Department of Primary Industries

OUT16/24394

Nyngan Scandium Project (SSD 5157) Comment on the Environmental Impact Statement

Nyngan Scandium Project (SSD 5157) Comment on the Environmental Impact Statement Detailed comments – DPI Water

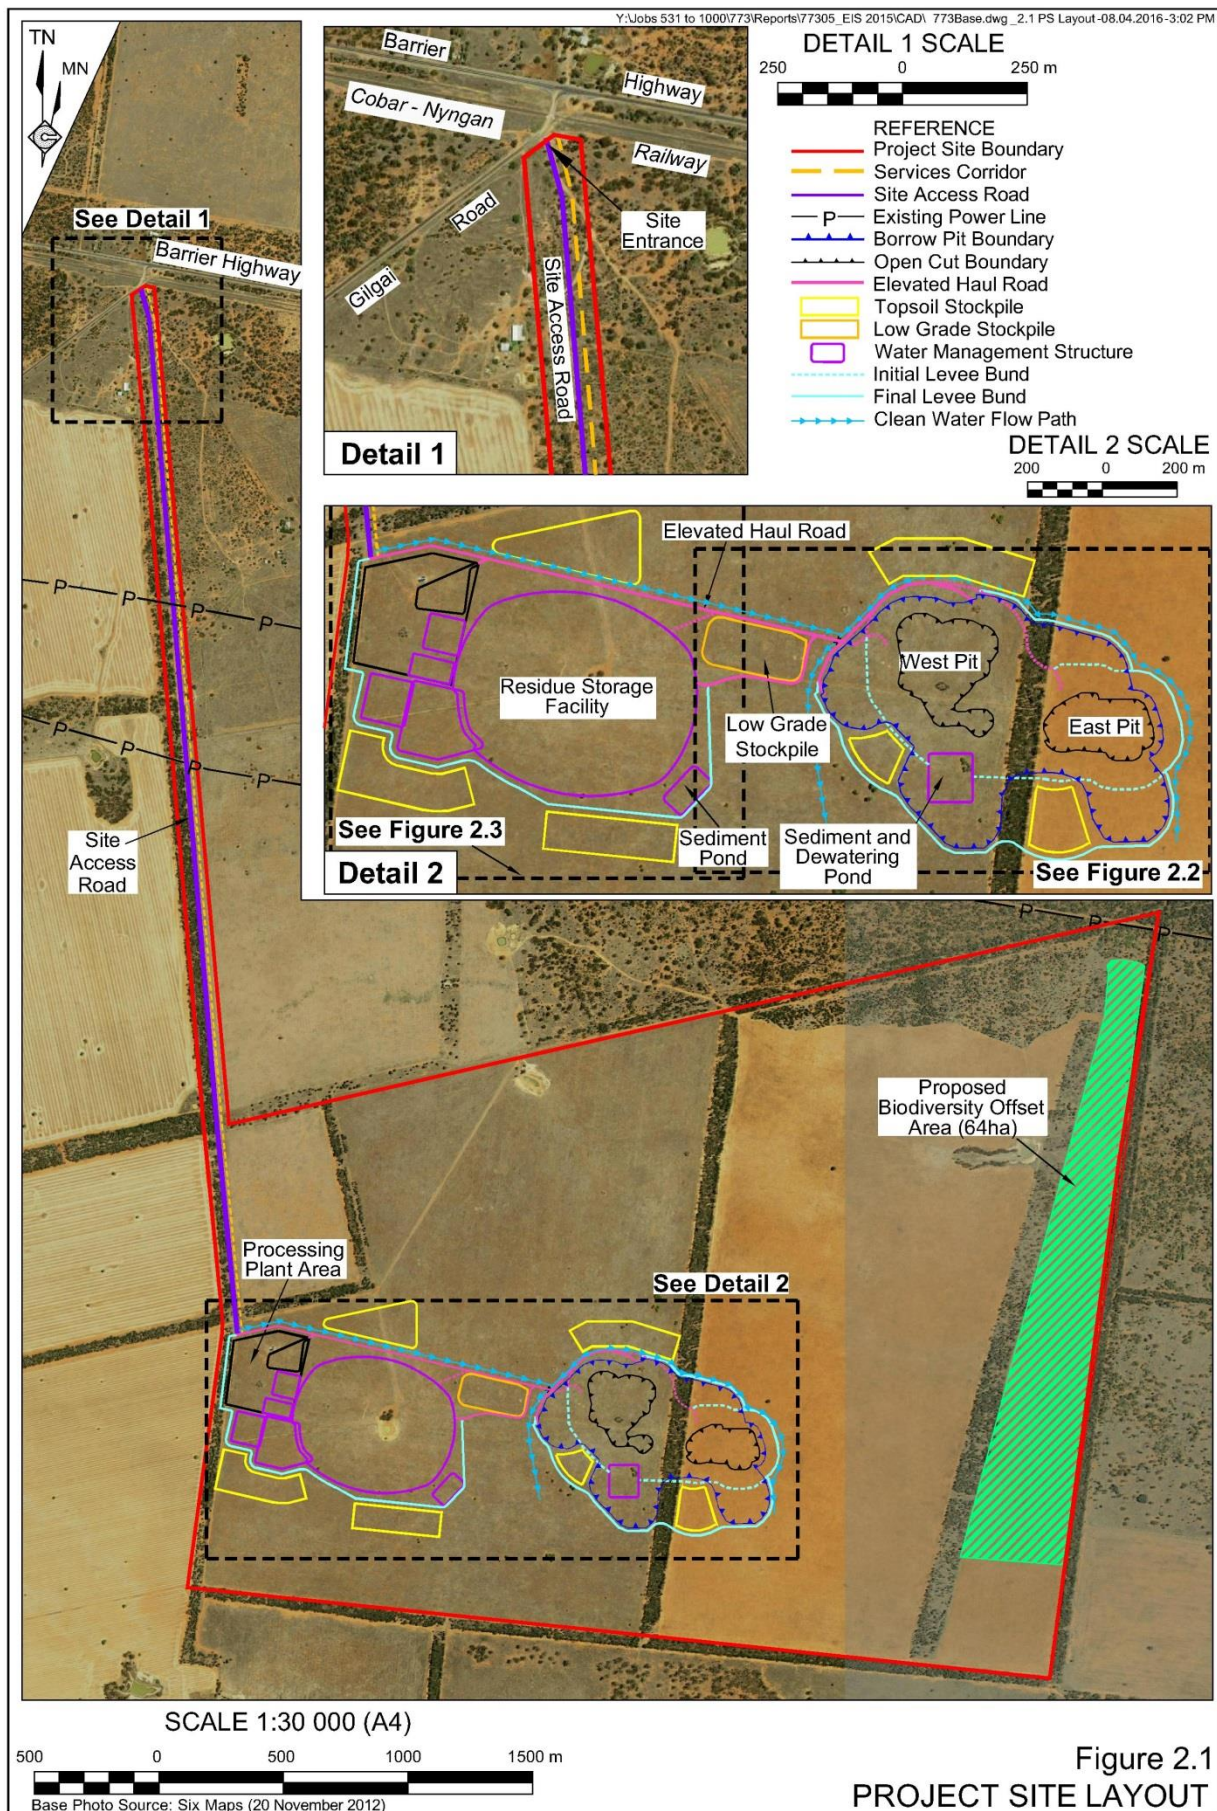
- Figure 2.1 of the main EIS indicates an initial levee bund is to be established close to the two pits, followed by a final levee bund on the outside of the borrow pit and outside of the majority of the infrastructure in the western side of the operations.

- Flood modelling is included in the EIS to determine the required height of the levee. This included modelling to depict the flood extent for the 1 in 100yr ARI and 1 in 1000yr ARI levels. The results from the 1 in 1000yr ARI event is proposed to be used as the design level for construction of the levee. The surface water assessment recognised there were limitations in the cross-section data that could be used in the flood modelling and recommended additional surveying be completed for more accurate assessment of the flood levels and final levee design. This is supported by DPI Water.

- The flood modelling has not included an assessment of the potential impacts of the proposed levee and other infrastructure (eg. topsoil stockpiles) on flood levels or extents within or outside the project area. Uncertainty therefore exists in terms of flood impacts on adjacent properties.

- The flood modelling and runoff assessment proposes a floodway to be established between the levee for the pit and the levee for the process plant area. This will require a culvert under the connecting road and relevant water diversion structures to convey water in a stable manner through the site. Further detail on clean, dirty and contaminated water management is requested as part of preparation of a Water Management Plan prior to commencement of operations. It is recommended this be consistent with standards in the guideline, *Managing Urban Stormwater: Soils and Construction* (Landcom 2004).

Figure 2.6
CONCEPTUAL WATER FLOW CHART

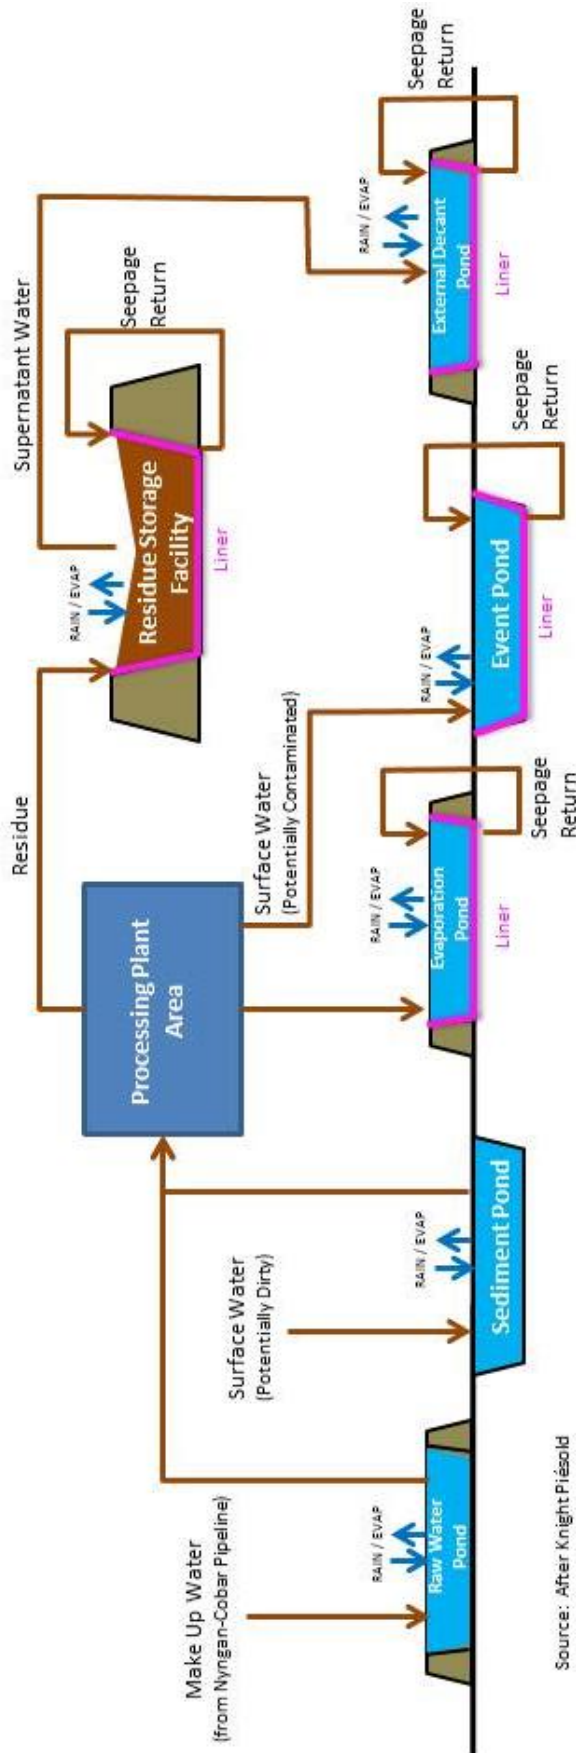
- Figure 2.6 of the main EIS indicates liners are proposed to be installed to mitigate impacts to groundwater quality for storages proposed to store contaminants. This is to include the residue storage facility, evaporation pond, event pond and external decant pond. The lining is proposed to vary depending on the time period that contaminants are held. It is recommended consideration be given to the ability to manage impacts based on time of exposure and how this equates to a lower risk to the groundwater source. DPI Water supports the use of adequate liners to mitigate the potential for degradation of groundwater quality within 40m of the activity in accordance with the NSW Aquifer Interference Policy both during operations and post mine life.
